# City of Albuquerque Stormwater Construction Site Inspection Report

ESC File No.	C11E004	Project Name:	Rosa Parks Stockpile Yard
NPDES Id. No.	NMR1004ZB	Location:	Rosa Parks and Kimmick
8/10/2022	Owner	Contractor	
Operator	<a href="mailto:Steve.Metro@wilsonco.com">Steve.Metro@wilsonco.com</a> NMR100504	<a href="#">Guzman Construction</a>	
Contact name & title	Altagracia Pena NMR100501	Lutita Pena, NMR1004ZB	
e-mail	<a href="mailto:lupita@guzmancs.com">lupita@guzmancs.com</a>	<a href="mailto:lupita@guzmancs.com">lupita@guzmancs.com</a>	
Contact Phone #	505-341-8591	AP452-0663 SM280-4553	
COA Inspector	Doug Hughes	Start/End Time:	3-4pm
Construction Phase:	Staging		
Type of Inspection:	Regular	Storm Event	Past Storm Event >0.25" 311/Complaint Follow Up
Weather at time of inspection?	Cloudy	Temperature:	~ 90
Estimated date of last storm 0.25" or greater	7/24/2022

ESC-1

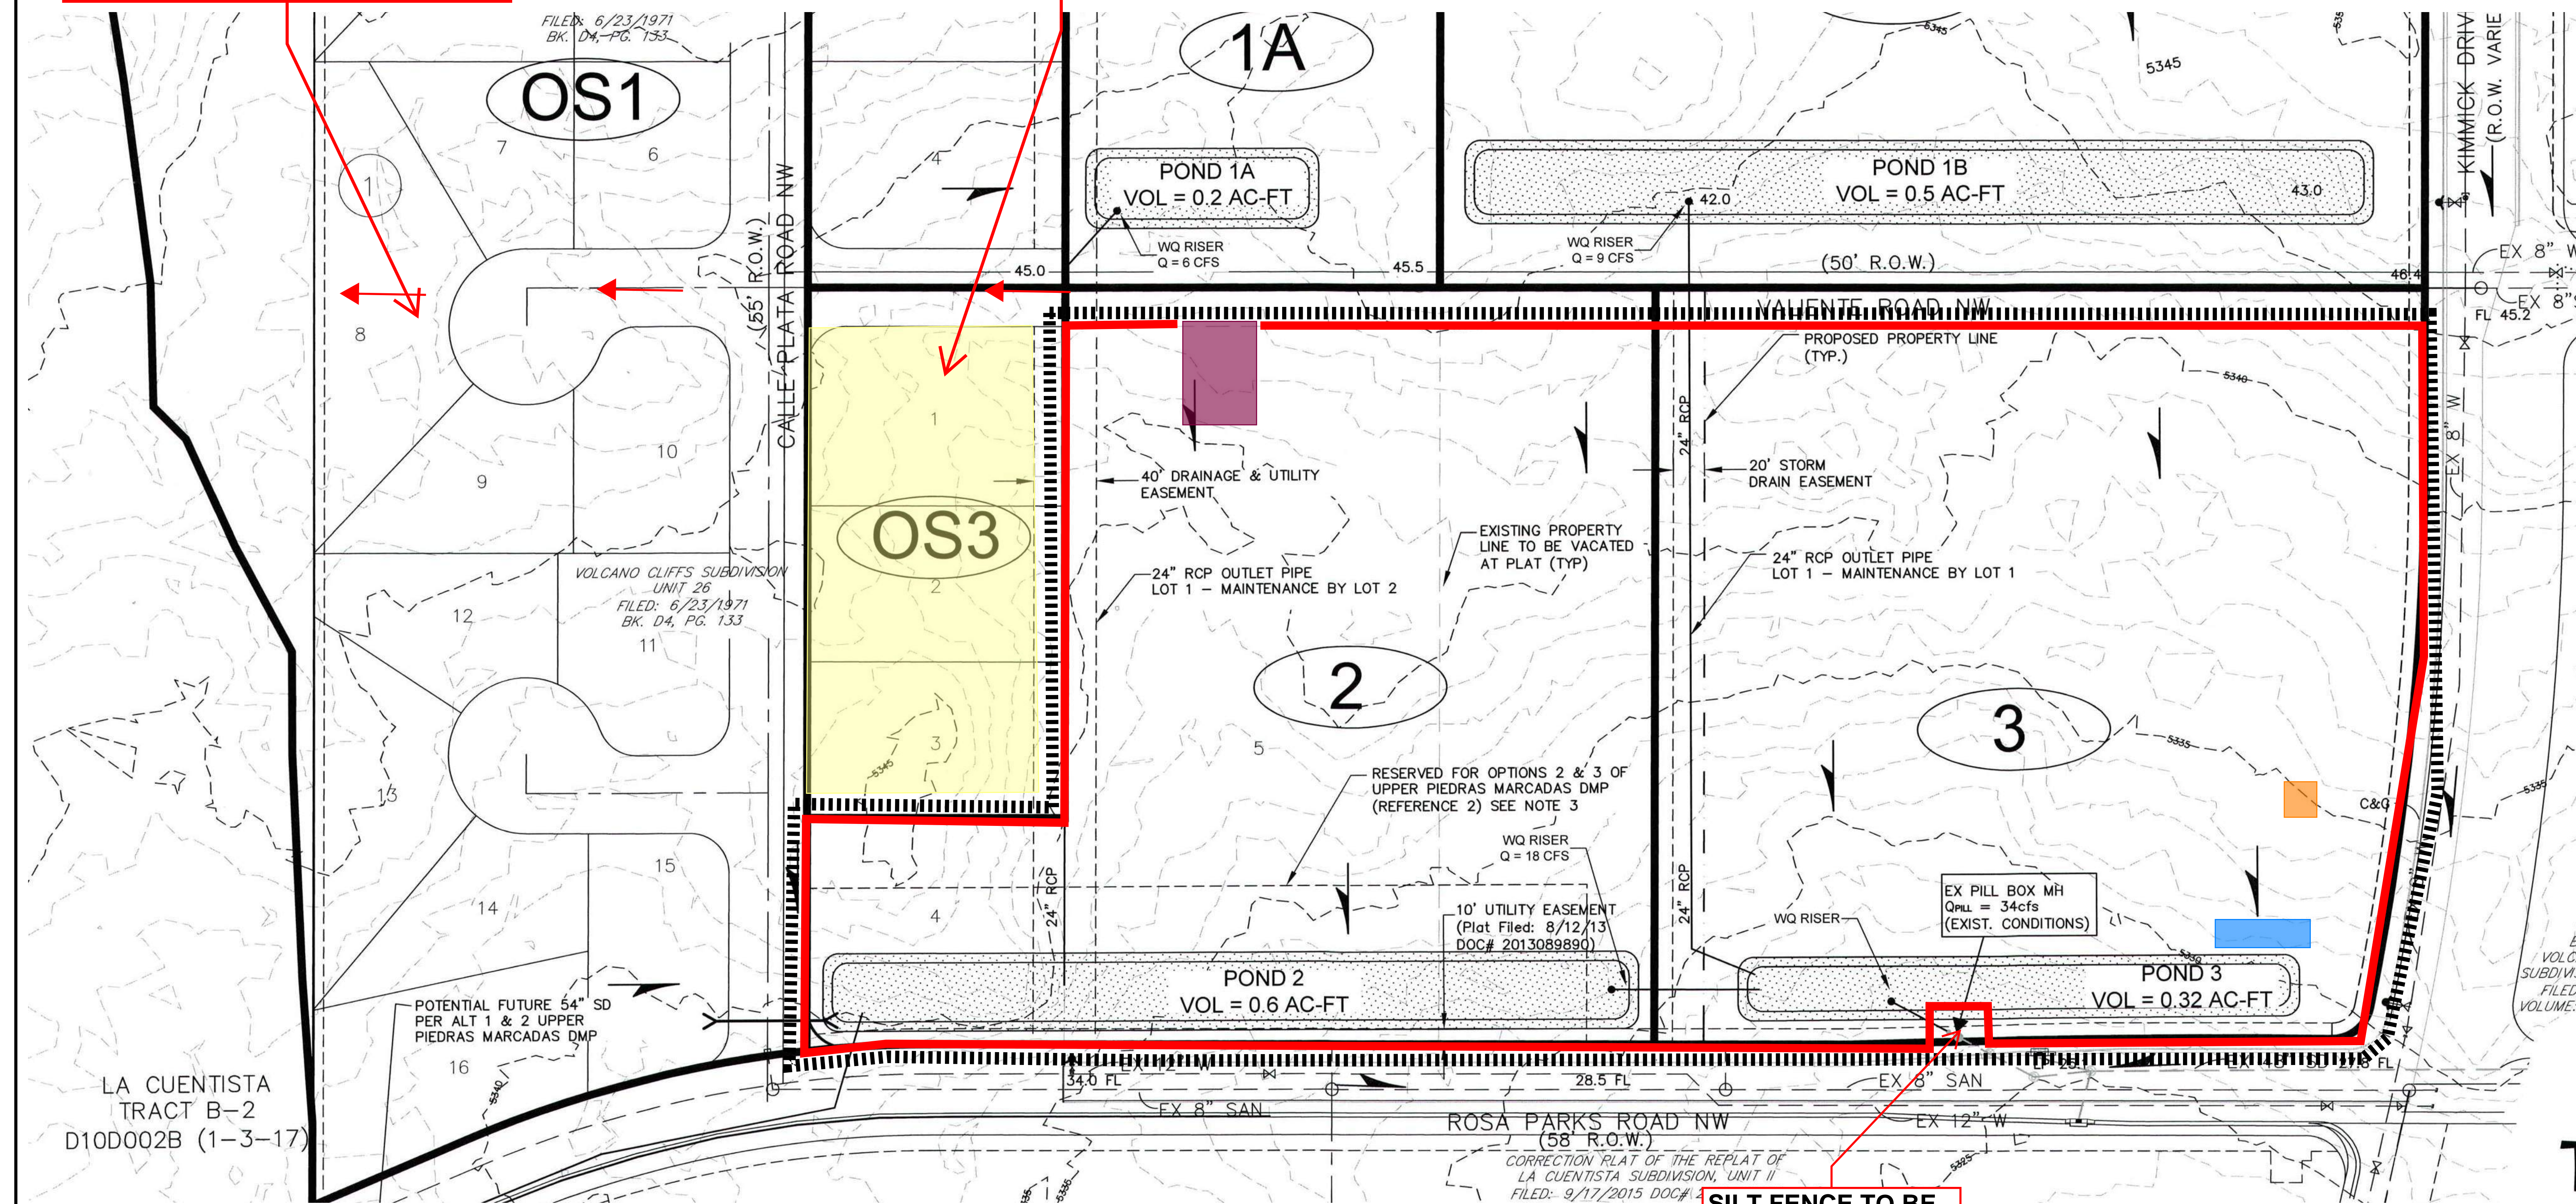
Item Number	Deficiency/ Corrective Action		
1	BMPs were missing.		
2	Neither the NOIs nor Stabilization has been provided for Tracts 1-3 of Block 6 .		
3	Three NOIs and operator Certifications are missing from the SWPPP. The signature on the SWPPP Certifications must match the signature NOIs, specifically Lupeta, Altagracia, and Steve Certified the NOIs and must Certify the SWPPP with their wet signatures. Deligation of Authority if applicable, must signed by the same corporate officer that signed the NIOs. Verify that signatures meet the criteria in CGP Appendix G.11.		
4			
2.1	Discharge off site? (Y/N)	no	
4	Self Inspection Reports	n/a	Latest report Date: none

Notes:	
<p>The SWPPP is in Tom Meier's pickup onsite Ph 453-8625 <a href="mailto:thomas.Meier02@icloud.com">thomas.Meier02@icloud.com</a>. Tom is Guzman's DA. Tracts 1-5 Block 6 are entirely covered by recent land disturbing activities. There is also a large area of land disturbance on the portion of Tract 1 Blk 2. The site is mostly inactive, with the exception of water trucks going back and forth between the hydrants on the east and La Cuentista III on the west.</p>
